Application Reference: 2026/0177

Site Address: 2 Cliffe Close, Brierley, Barnsley

Introduction: This application seeks full planning permission for the erection of single storey rear and side extensions.

DRAWING NO: 2002
 DRAWING TITLE: PROPOSED PLANS AND
 ELEVATIONS

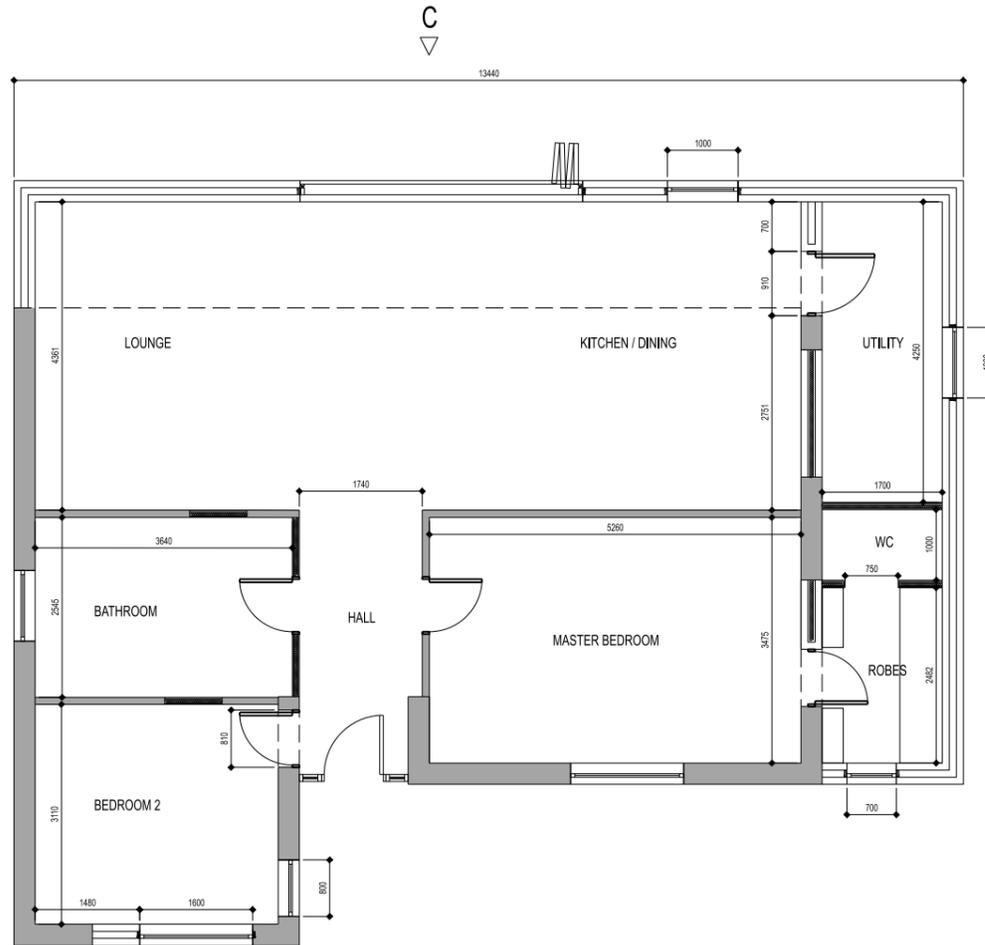
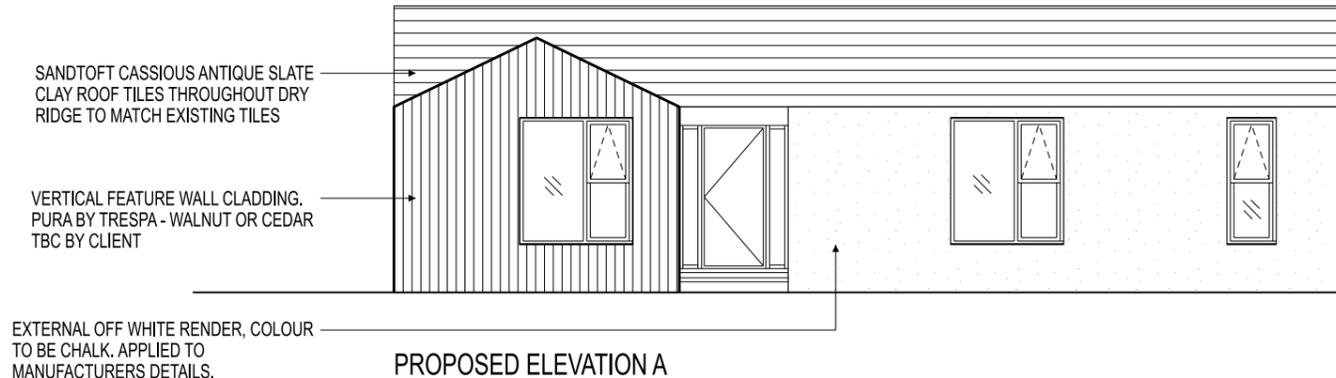
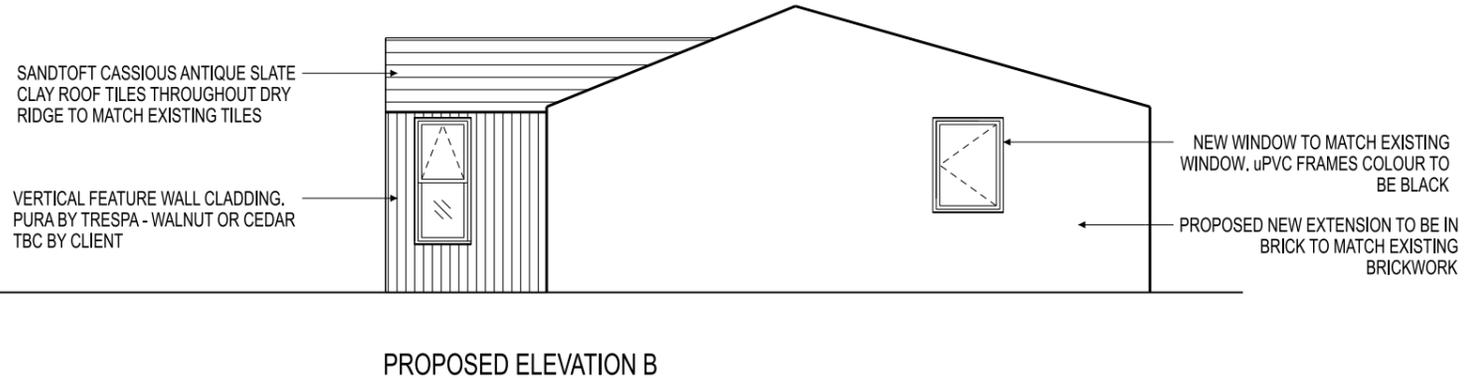
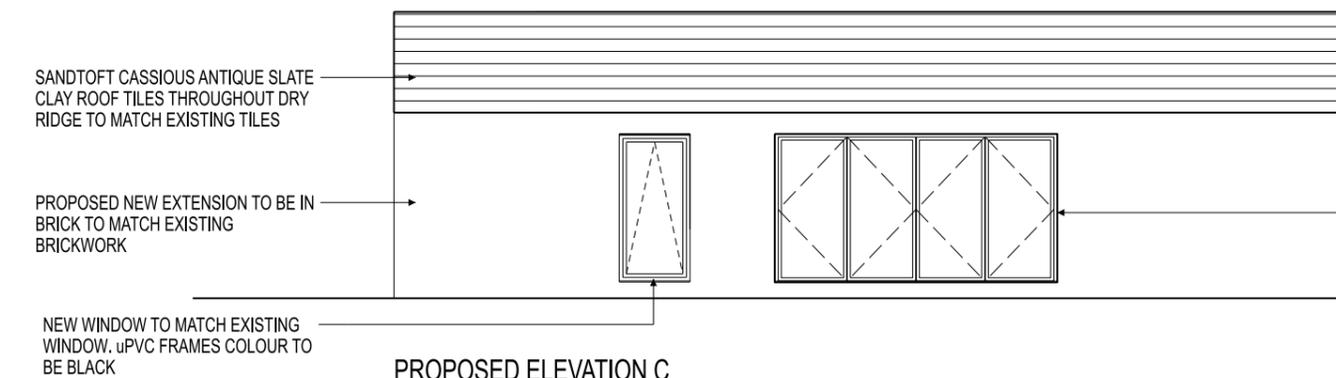
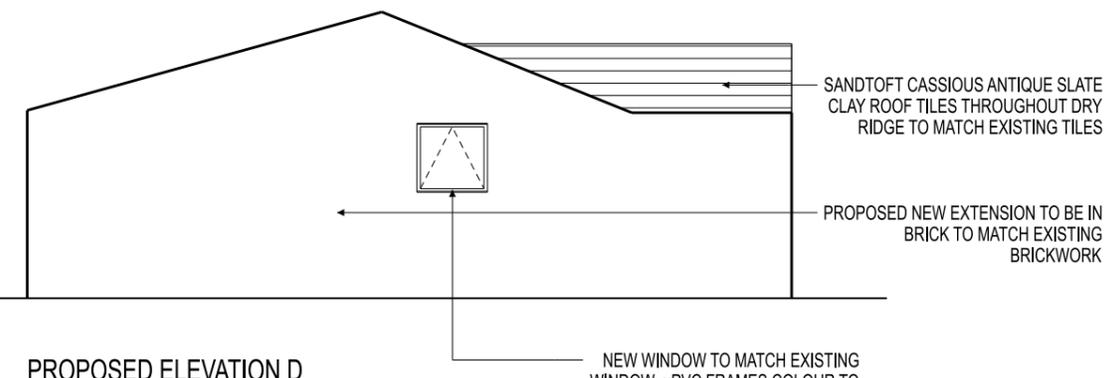
The design of the proposed extension is acceptable and complements the existing dwelling well, but it must be noted that there is no step down of the roof or set back of the elevation. On this occasion, the practicality of achieving such design features, given the modest side projection and height of the proposal, it would be difficult to achieve, and the side extension, along with the original front

The amended plans removed the originally proposed cladding and render from the dwelling. The amendments now show matching brickwork, which would retain the original character of the dwelling and would continue to align with the other bungalows within the street. What would be altered though is the scale and design of the windows, across the whole bungalow. In mitigation of this, whilst the existing windows retain the same style, they are dark frames instead of white, as found on other bungalows. Additional mitigation arises from the fact that all windows on the front elevation would match each other, and together they share a similar design to the windows featured within the contemporary dwellings opposite on Cliffe Lane.

The proposed front extension, which would be considered as permitted development, as it would be less than 3sqm, is in the form of an infill of a current inset within the front elevation. As the proposed glazing and door complement the proposed new windows. It would not be expected to have any negative impact.

The rear extension features a rear projection of approximately 1.5m, which is below the 4m which could have been constructed through permitted development, if it was not connected to the side extension and its height was under 4m. With such a modest projection, there already would be a minimal impact on the unattached neighbouring dwelling.

With the neighbouring dwelling featuring a relatively large detached garage, close to the rear elevation of their dwelling, and boundary treatment between it and the application dwelling; despite the approximate 4.05m of the extension, there would be little or no impact to the neighbouring dwelling, with any impact exceeded by the impact of their own garage.

With the proposed extension being single storey and approximately 7.2m from the rear boundary, there would be no concern to the impact on neighbouring dwellings to the rear or other dwellings within the street scene.

The proposal does build upon the current driveway which passes along the western elevation of the dwelling. However, with no increase to the current number of bedrooms, only one parking space of a minimum dimension of 2.5m by 5m is required for a two bedroomed dwelling, and according to the plans, just over 10m of driveway length would remain. The width of the driveway would be unaltered and appears to be over the 2.5m width required, which with the 10m length, potentially provides two in curtilage parking spaces. With no proposed changes to access, there would be no impact on parking provision or highway safety.

- The proposed rendering of the dwelling, and installation of cladding was removed from the plans as it would have not been deemed in accordance with local policy D1: High Quality Design and Place Making.

2. The development hereby approved shall be carried out strictly in accordance with amended plans
 - Existing Floor Plan and Elevations Drawing NO: 2000
 - Proposed Floor Plan and Elevations REV A Drawing NO: 2002 Rev A
 - Site Plan Drawing NO: 2000
 - Location Plan PP-14745822v1

3. The external materials shall match those used in the existing building.
